**A57 Link Roads**

**9.72 Addendum to the Statement of  
Common Ground with High Peak Borough  
Council**

- 1.1.1. This document provides an update on the ongoing dialogue with High Peak Borough Council in relation to Air Quality matters. The document has been produced in response to the Issue Specific Hearing 3 held on the 5<sup>th</sup> of April 2022 in lieu of a full update to the Statement of Common Ground with High Peak Borough Council (REP2-018).

**6.4 Environmental Statement  
Figure 5.4 Air Quality EU Compliance Risk  
Assessment**

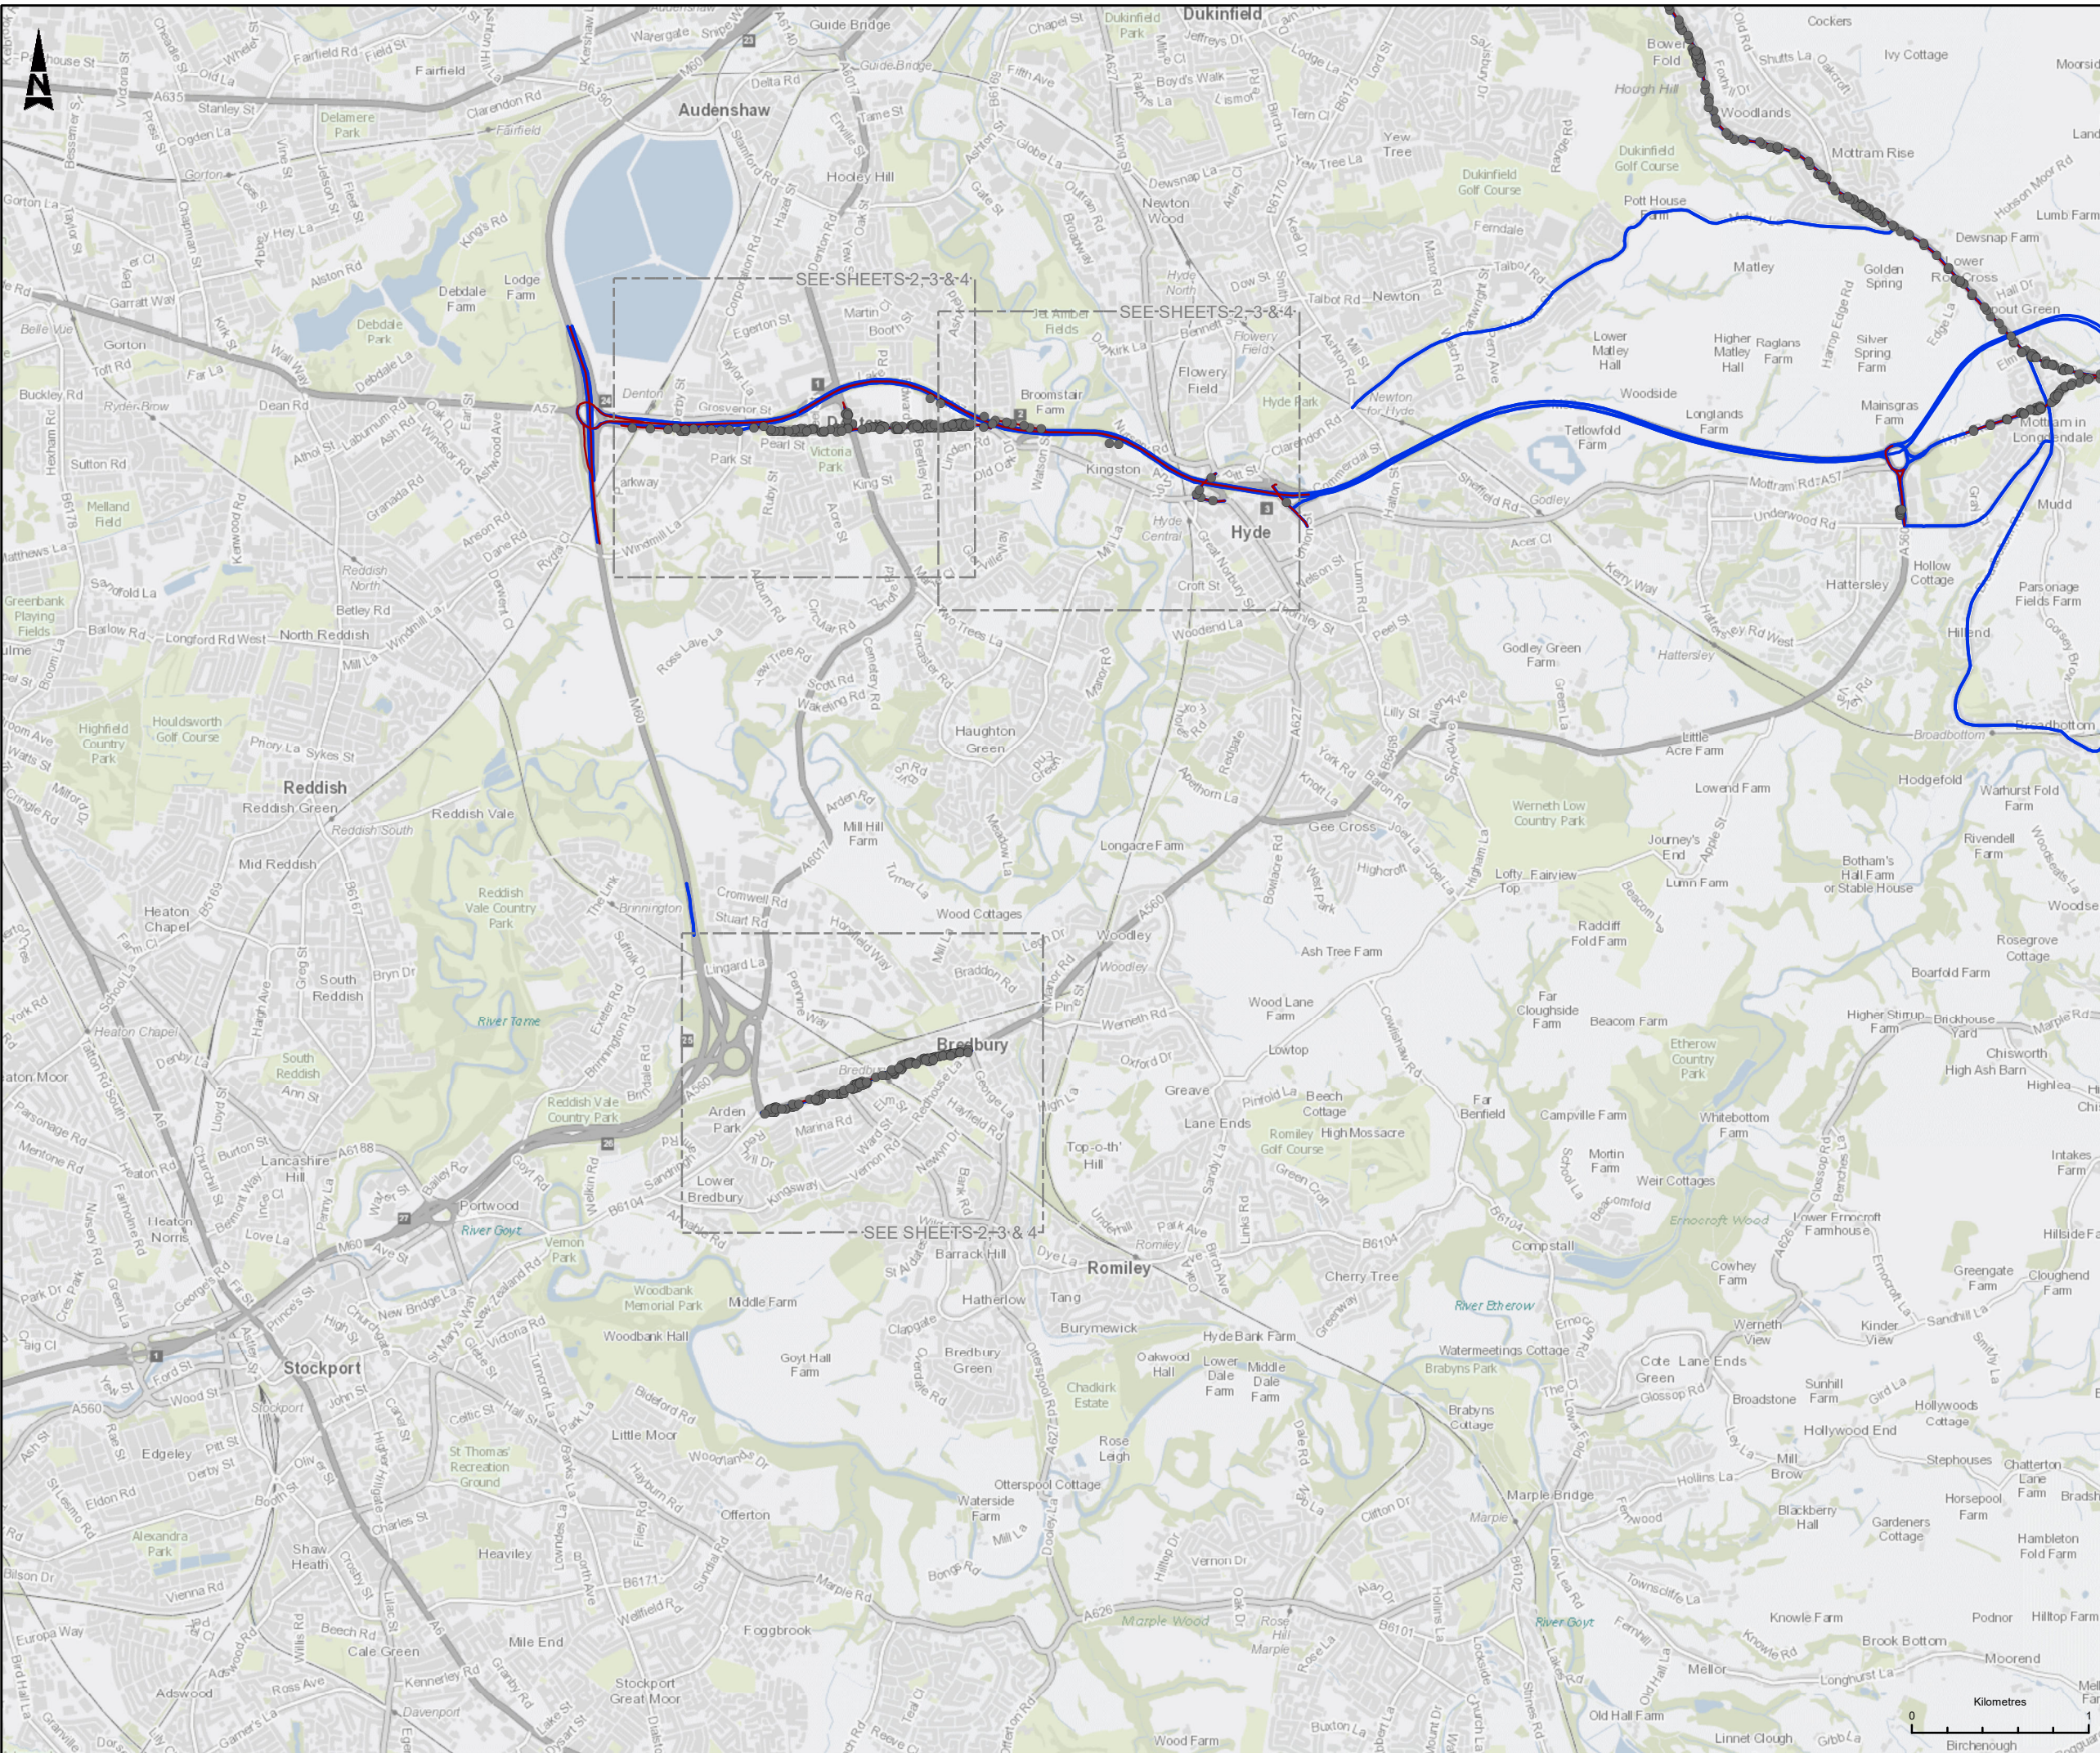
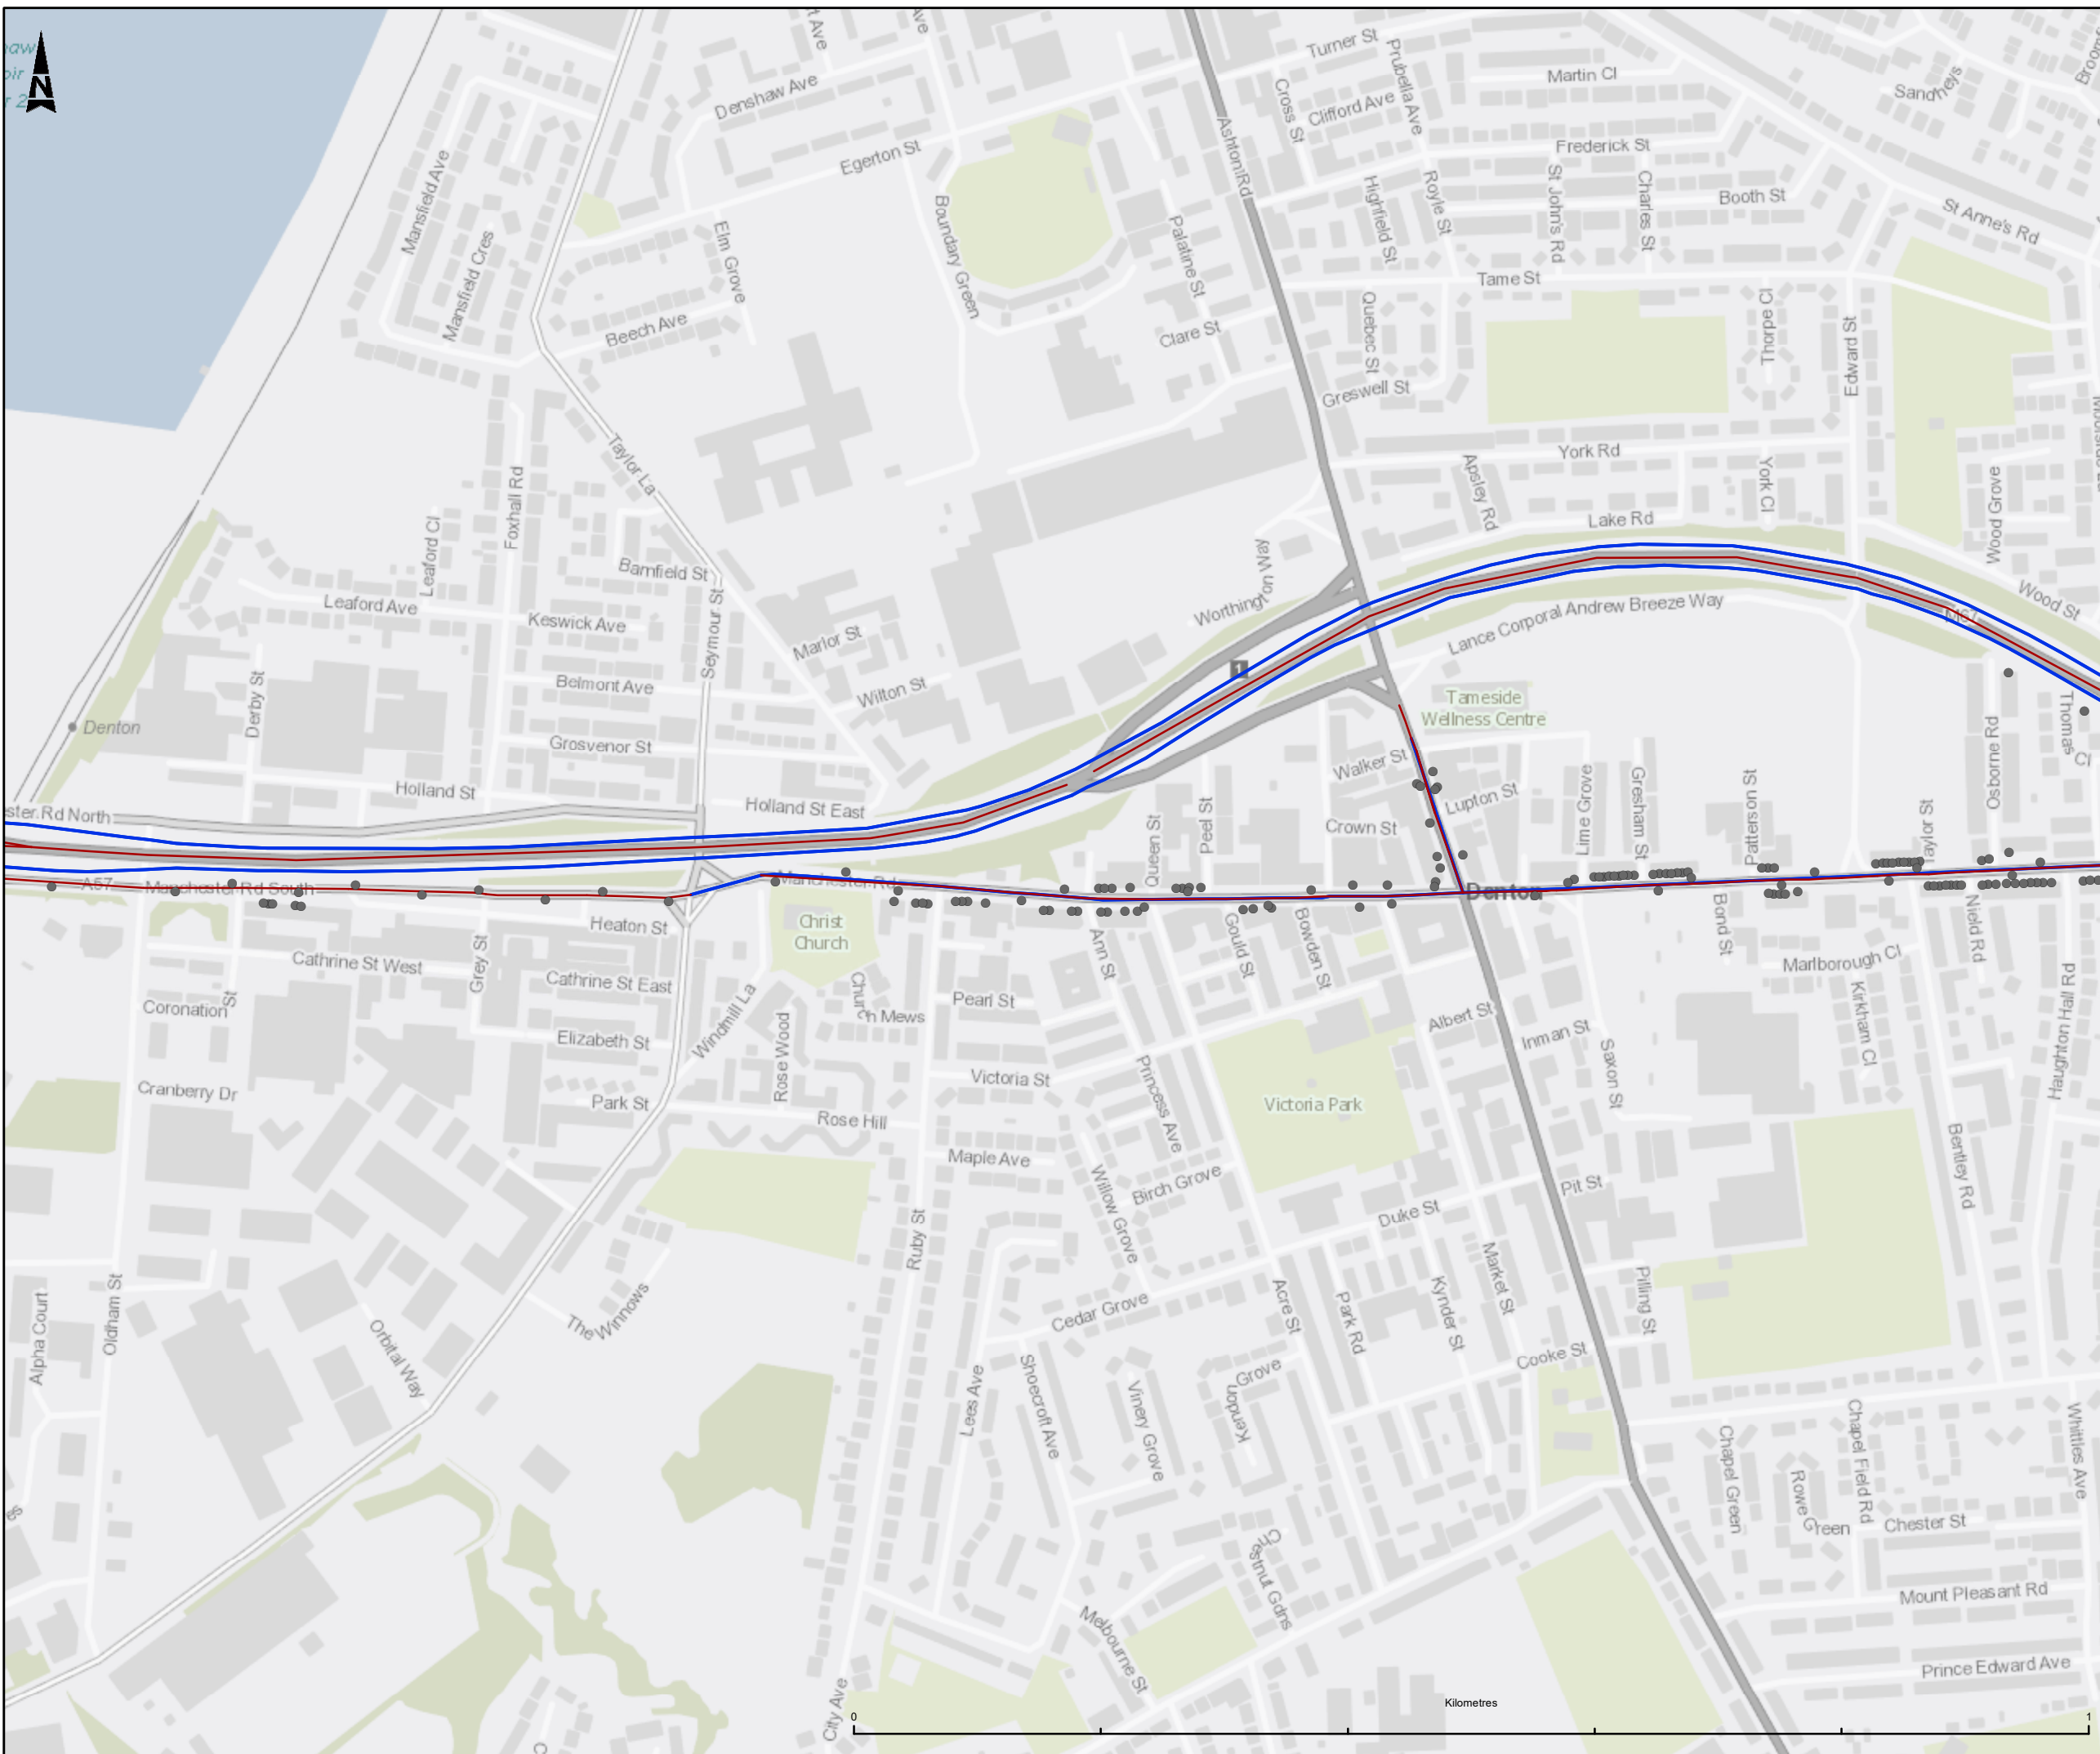
<b><u>Figure 5.4 Air Quality Compliance Risk Assessment – receptor labels</u></b>

HPBC Item	National Highways Position	HPBC Position	Status
<p><u>Item 8.38</u>            HPBC [REP4-011] asked for the A57 Brookfield qualifying features used in the NO2 compliance assessment to be labelled on ES Figure 5.4 [APP-080].</p>	<p>Given the number of qualifying features and public access receptors included in the compliance assessment it was not possible to practically label the qualifying features in ES Figure 5.4 (APP-080) however, an extract of ES Figure 5.4 zoomed in on the A57 Brookfield area with receptor ID labels for qualifying features and public access receptors adjacent to the A57 Brookfield is provided below this table.</p>	<p>Agreed  <u>Deadline 8 update (HPBC)</u>            It is noted that this response was supplied at deadline 7 by NH. Clarification of receptors did highlight that there were some relevant receptors in the Brookfield area that had not been included in general AQ assessment but had been included in the compliance assessment (see final row)</p>	<p>Closed</p>
